10 DEC 2019.

I am objecting to application FG/141/19/PL. This proposal bares little difference to the previous application, in size, squashed into space, visual obstruction, danger of open pond and aesthetically defaced view of Tamarisk way.

PROPOSED SOUTH (FRONT) ELEVATION 1:50.

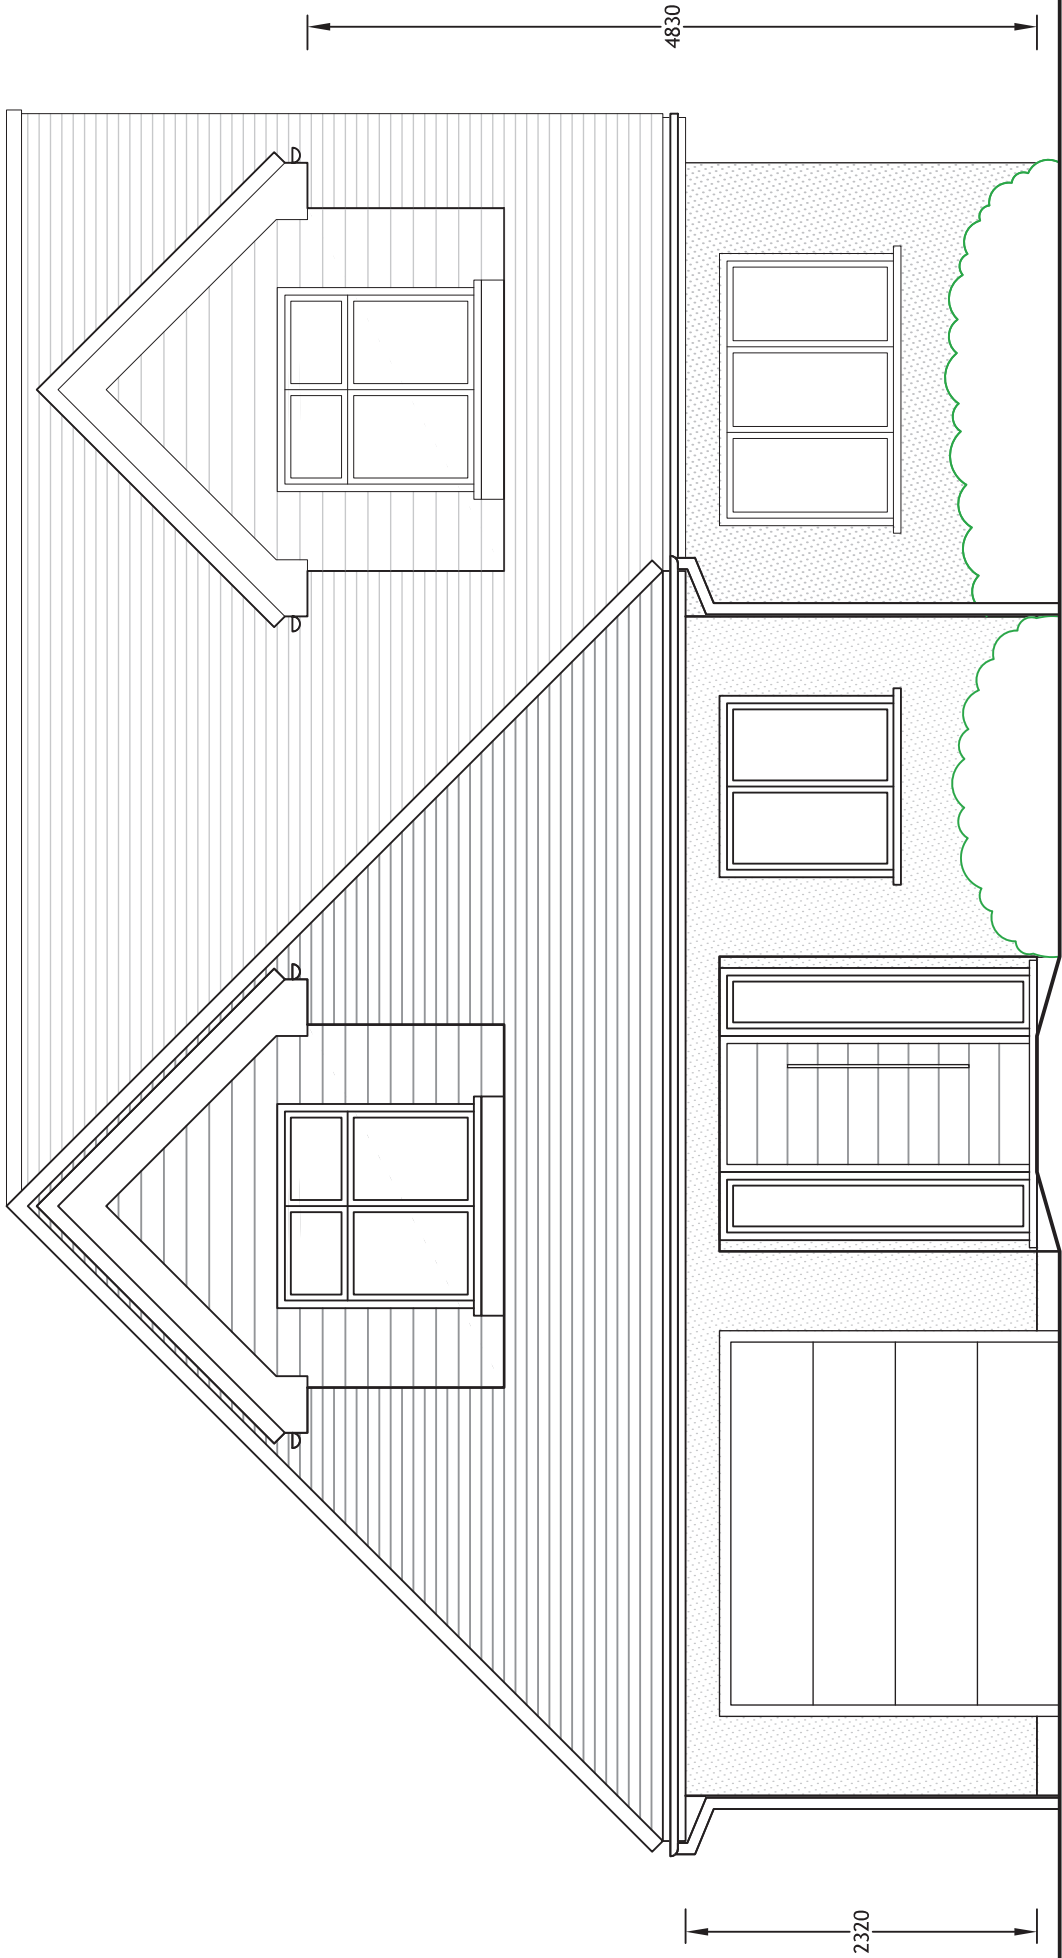
The new proposal changes the windows so as not to overlook neighbours property by use of opaque glass (No vision from either side of glass). If one-sided glass is used this can accidently be installed the wrong way on ~~reversed~~ reversed at a later date.

PROPOSED SITE PLAN

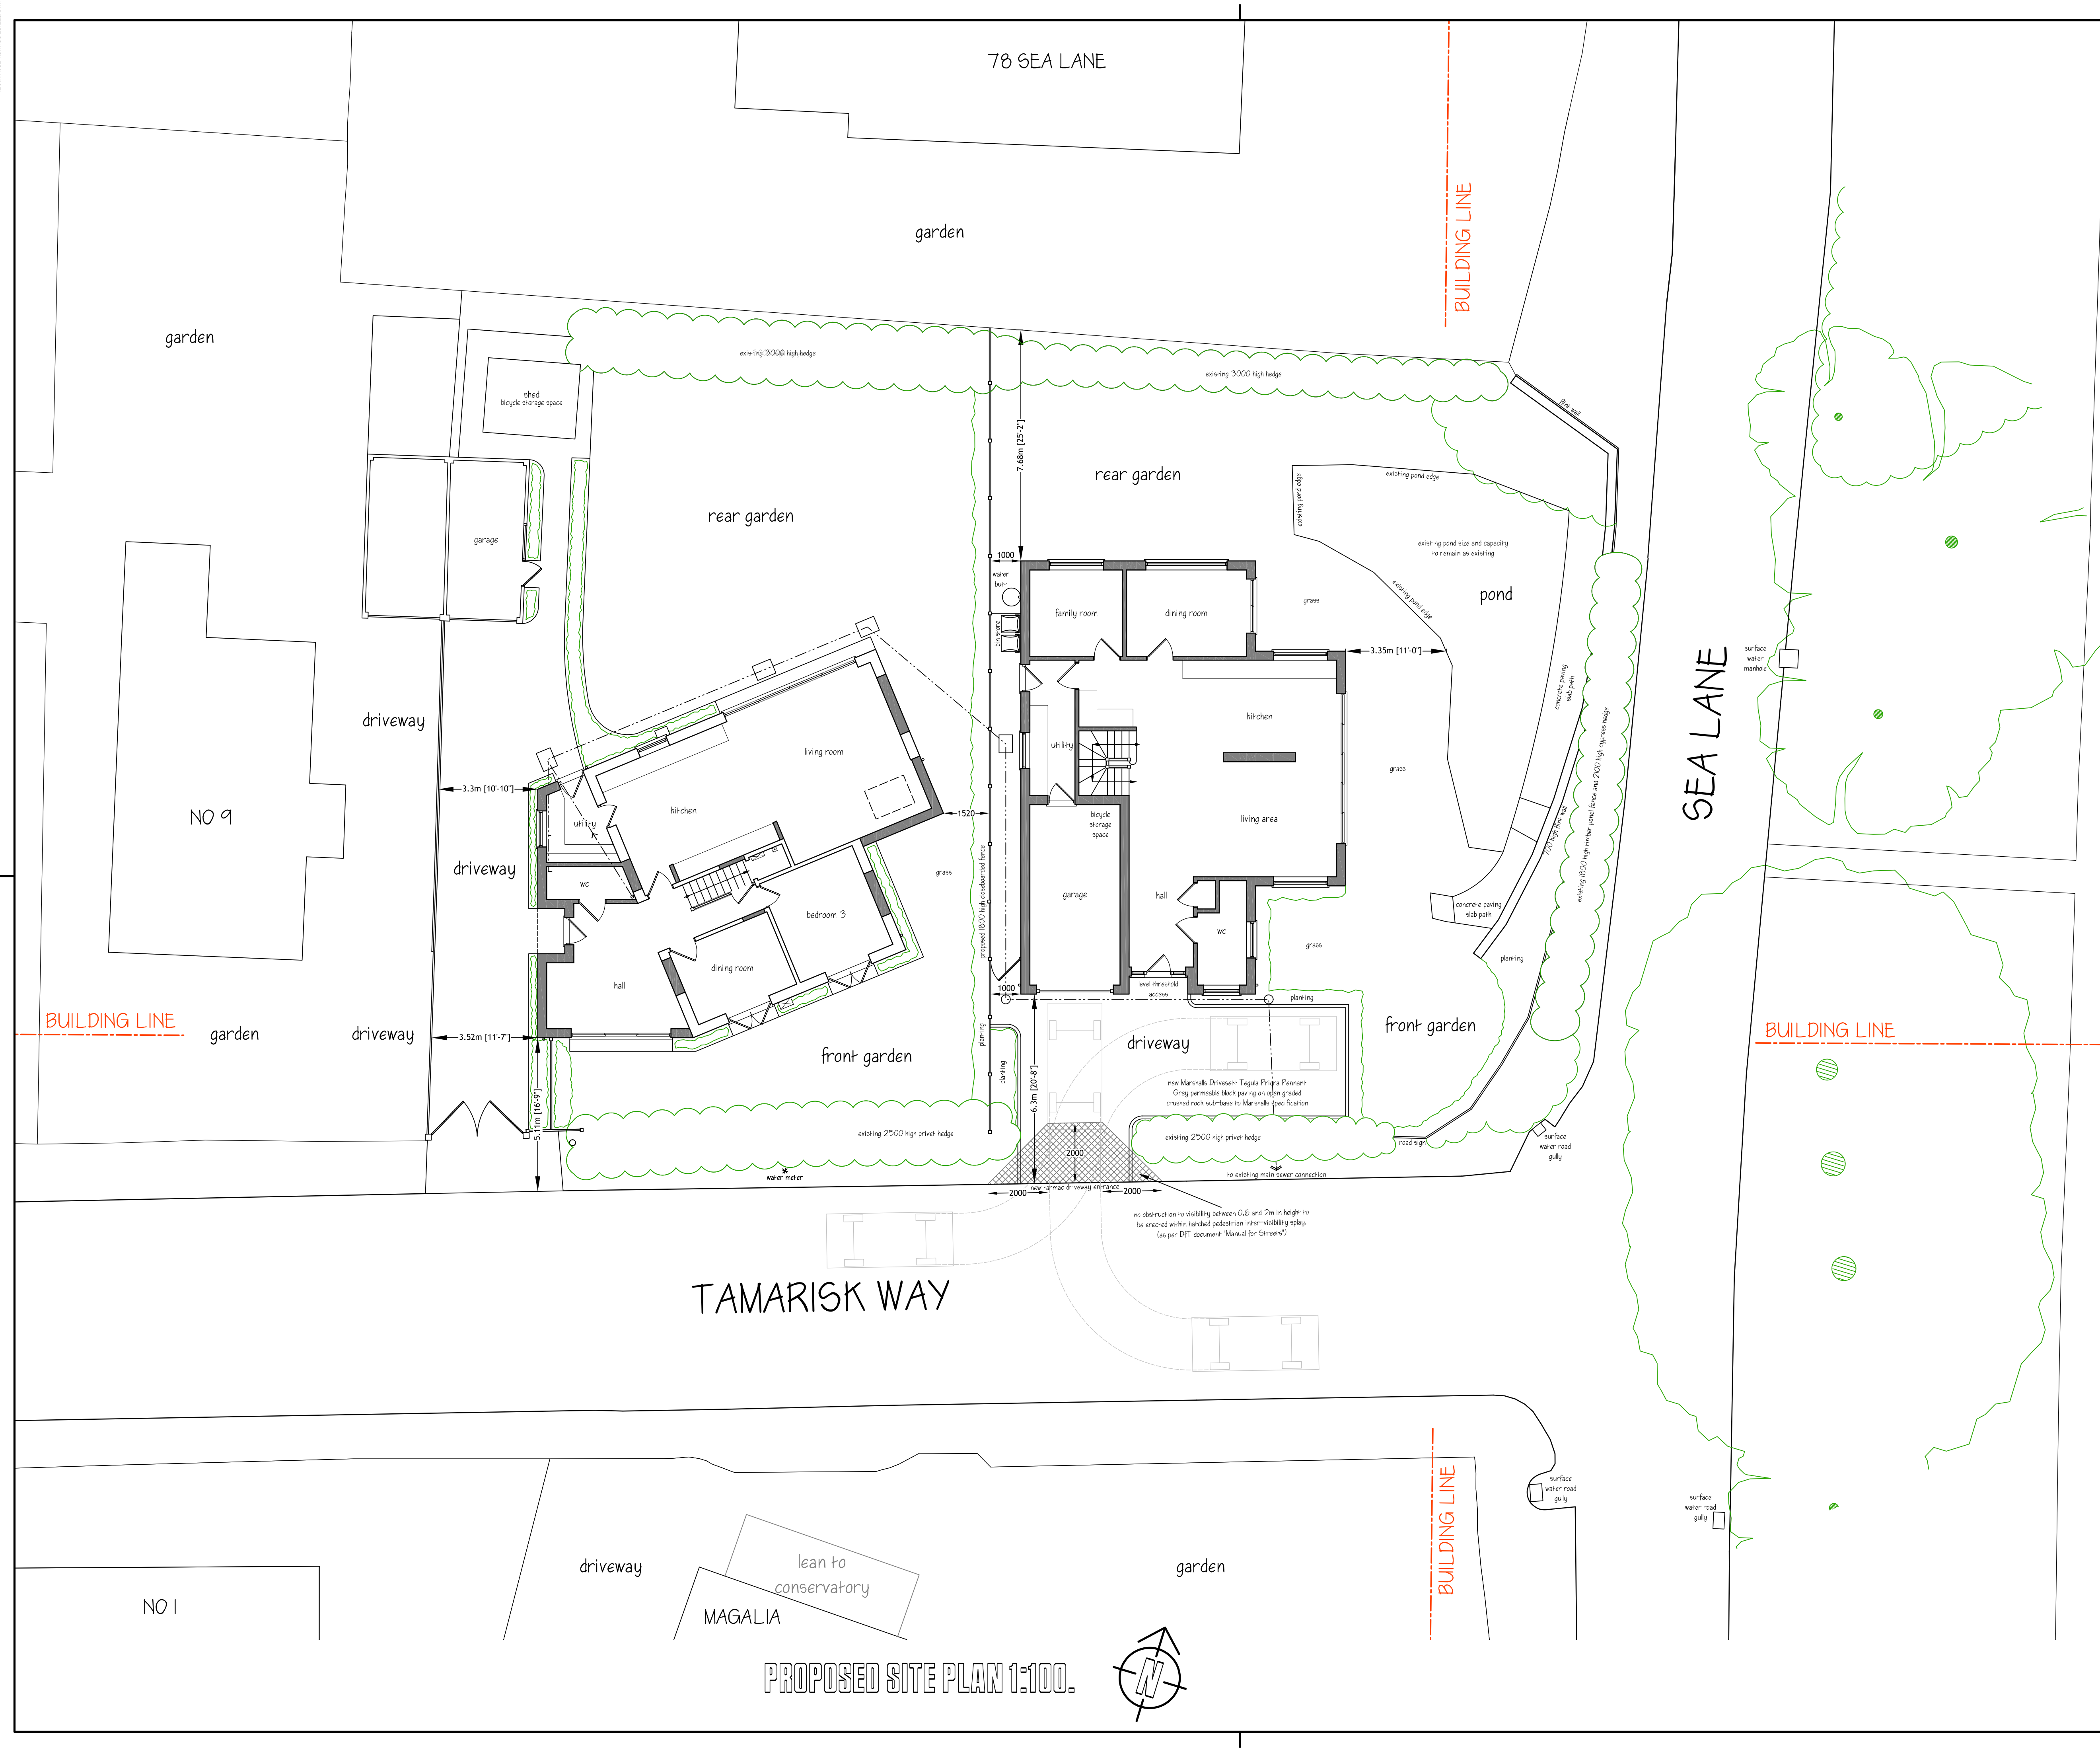
We are instructed to use permeable materials when laying a new drive, but this proposal will cover nearly all of the garden of Elm Lodge in concrete with possible risk of flooding (See the rain soaked corn fields opposite).
